TO: HON. TONY KELLY, THE MINISTER FOR PLANNING
Parliament House, Macquarie Street, Sydney 2000

15 December 2010

Re: Jones Bay Wharf Marina Development Pyrmont, Jones Bay Wharf, Pyrmont (MP09_0205)

Figure 3 - View 01 from cliff above Pirrama Road (proposed)

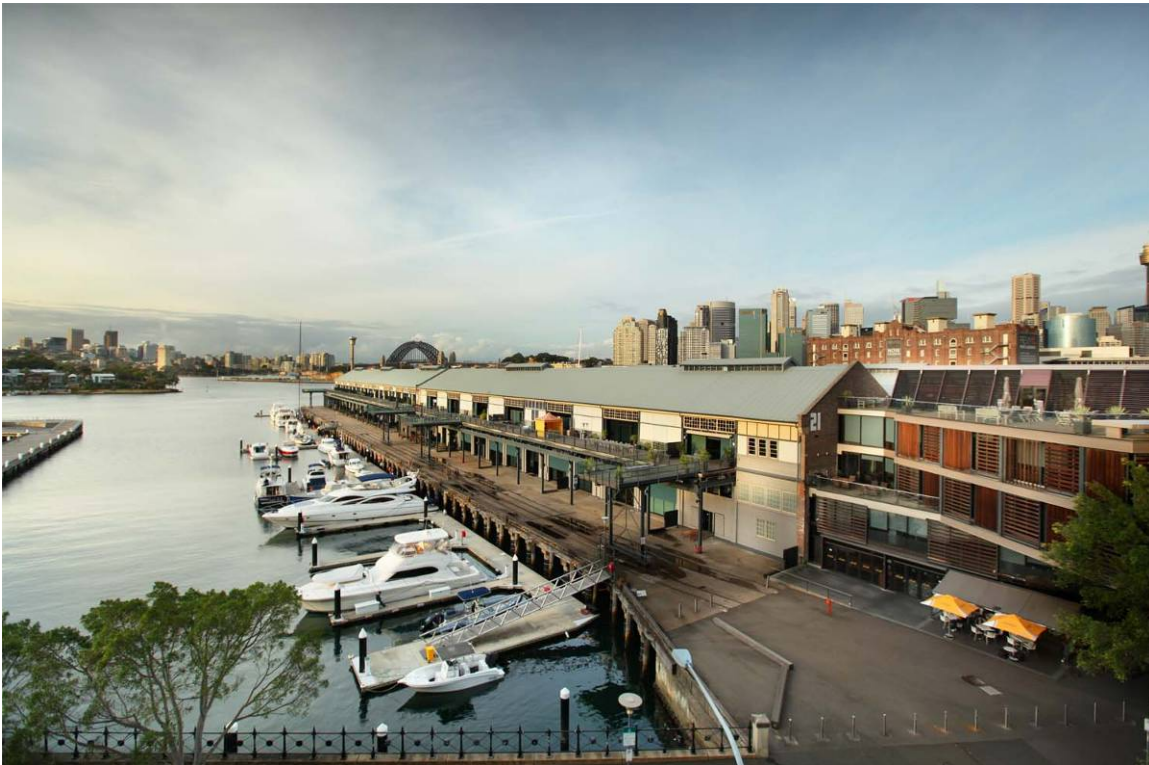
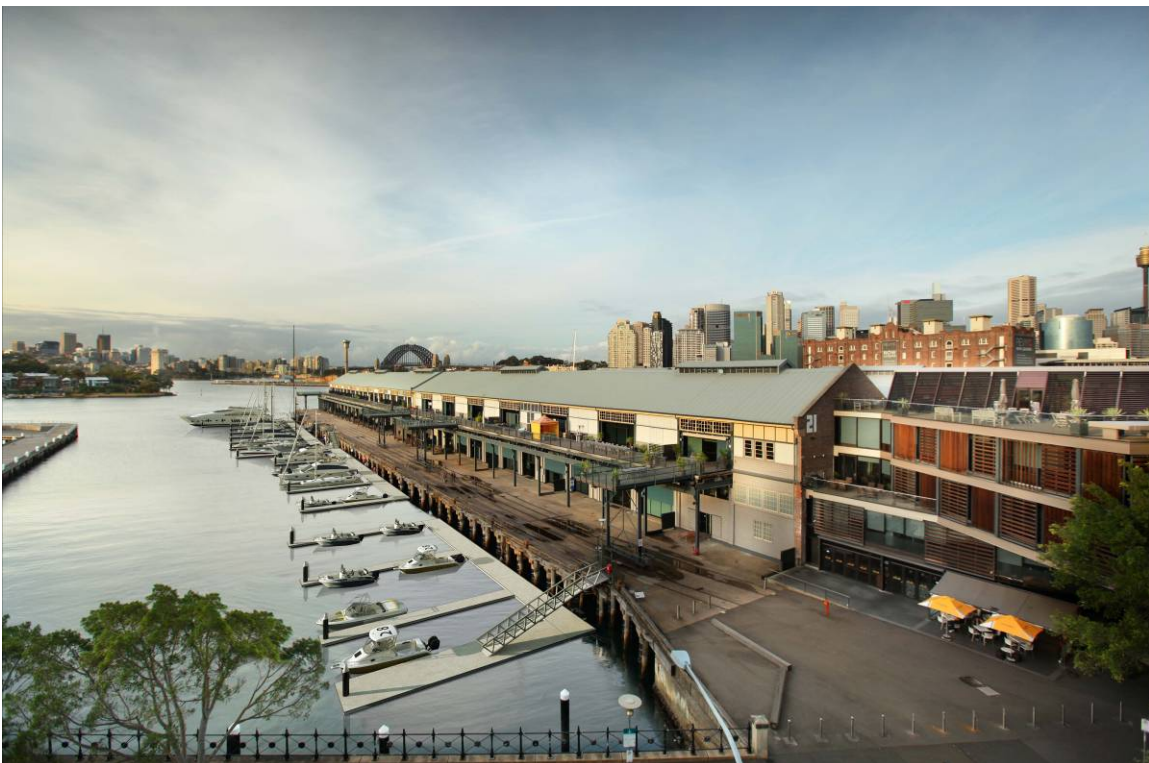
- The impact of the vessels heights and scale on the loss of views from suites and the local area has not been addressed and misrepresented in Toga Development No. 27 Pty Ltd supplied photomontages.
